**Colorado Springs Airport Advisory Commission Meeting
To Be Heard November 18, 2020
Land Use Review Item #07**

EL PASO COUNTY BUCKSLIP NUMBER(S)/FILE NUMBER(S): CR201 COMMERCIAL SITE DEVELOPMENT REZONE		PARCEL #(S): 5408001008, 5408001029, 5408001032 - 1034, 5408001041 - 1042 5408001051 - 1052
DESCRIPTION: Request by Kimley-Horn & Associates on behalf of Colorado Springs Equities, LLC for approval of Crossroads North rezone. The rezone includes 25.18 acres from Industrial (M) (4.84 acres) and Limited Industrial (I-2) (20.34 acres) zones to the Commercial Regional and Commercial Airport Overlay (CR, CAD-O) zoning district for a home improvement center, movie theater, sports complex and retail pad sites. The property is located northwest of the intersection of Highway 94 and Marksheffel Road. <i>Review Note: The Crossroads Metropolitan District was reviewed with recommended conditions by the Commission in June 2020.</i>		
CONSTRUCTION/ALTERATION OF MORE THAN 100 FEET ABOVE GROUND LEVEL? No	DISTANCE/DIRECTION FROM COS: 1.9 miles north of Rwy 17L

CROSSROADS NORTH REZONE

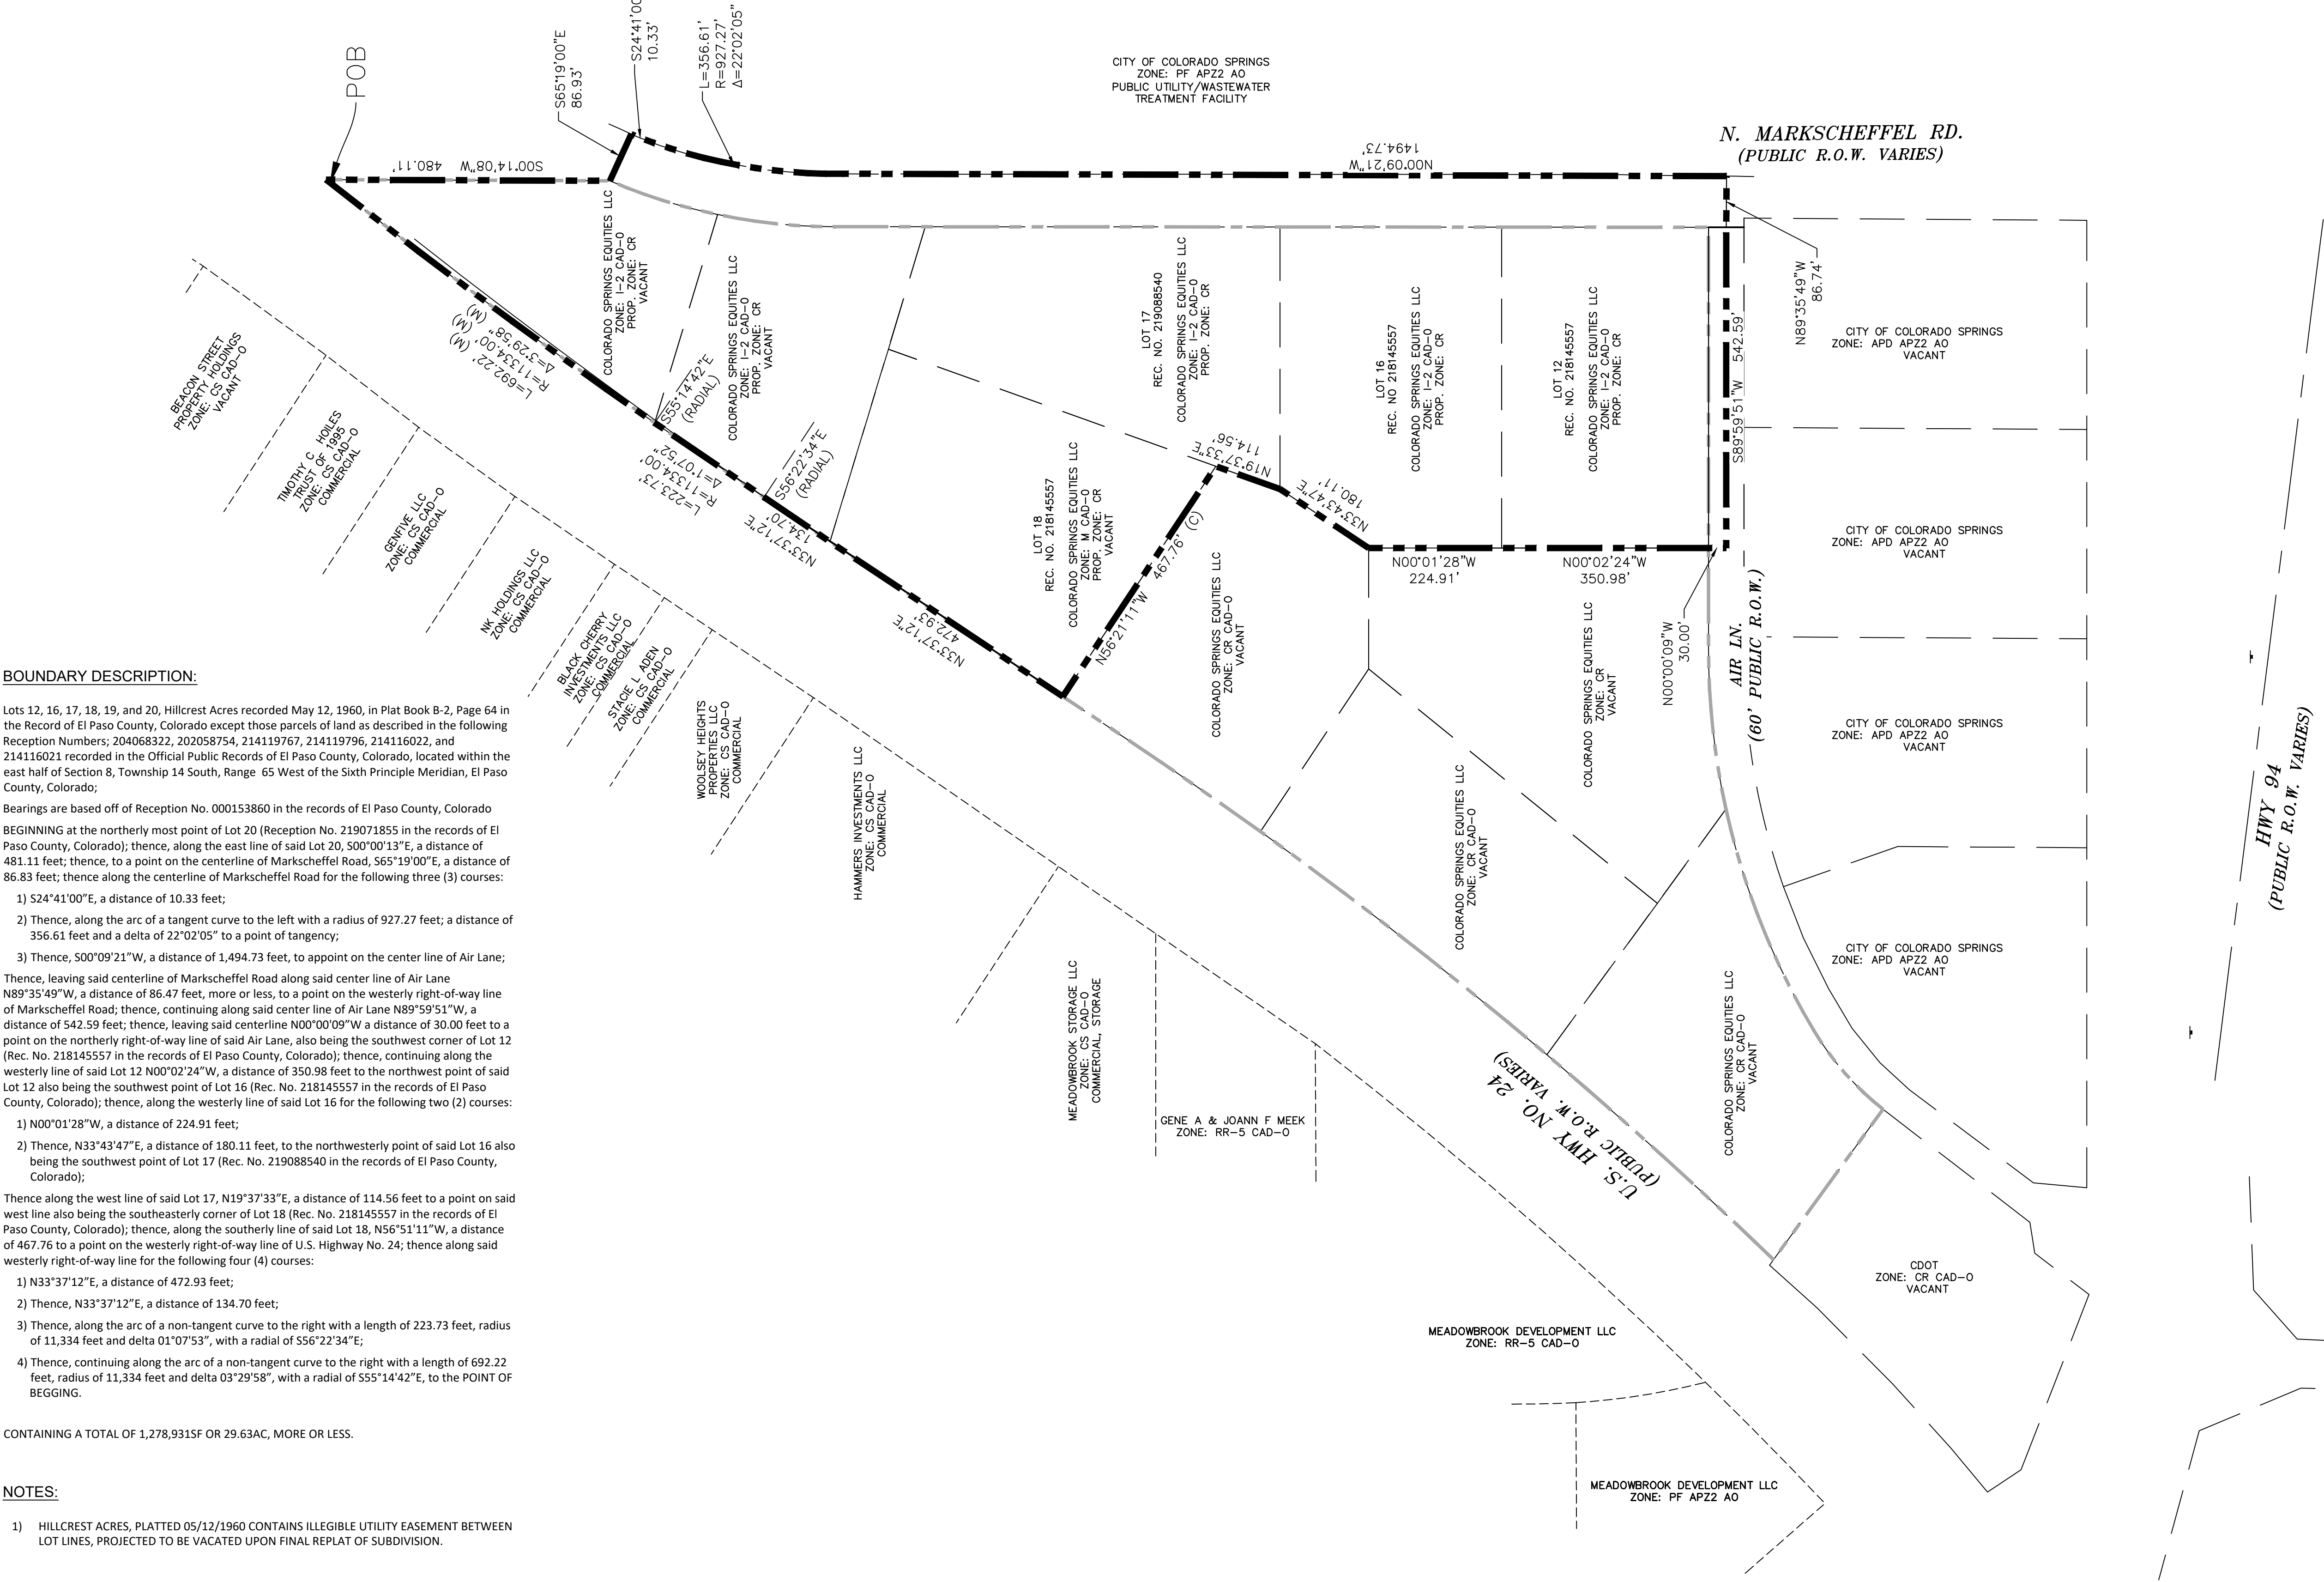
- **ADNL:** The development is within the ADNL Airport Noise subzone of the Commercial Airport Overlay District, as adopted by El Paso County.
- Residential use is not compatible within the 65 DNL noise contour and no residential development is permitted within the 65 DNL contour.

- No development that creates mass gatherings is permitted.
- The approval of this land use item by the Airport and the AAC does not constitute as any commitment, agreement, or other to the land owned by the Airport indicated as a future inclusion area.

- Other uses may require the indoor noise reduction requirement as outlined in Section 4.3.1 of the El Paso County Land Development Code.
- **Avigation Easement:** An Avigation Easement or proof of previous filing (book/page or reception number) is requested.

- **APZ-2:** The proposed is within the Accident Potential Zone 2 (APZ-2) subzone of the Commercial Airport Overlay District, as adopted by El Paso County. The proposed uses associated with this development appears to be permissible in the APZ-2 subzone.

- **FAA Form 7460-1:** Based on elevation data and distance to runway, the applicant will need to file Federal Aviation Administration (FAA) Form 7460-1 "Notice of Proposed Construction or Alteration" for any new vertical development at this site, including temporary construction equipment, and provide FAA documentation to the Airport before the commencement of construction activities. FAA's website <https://oeaaa.faa.gov/oeaaa/external/portal.jsp>.
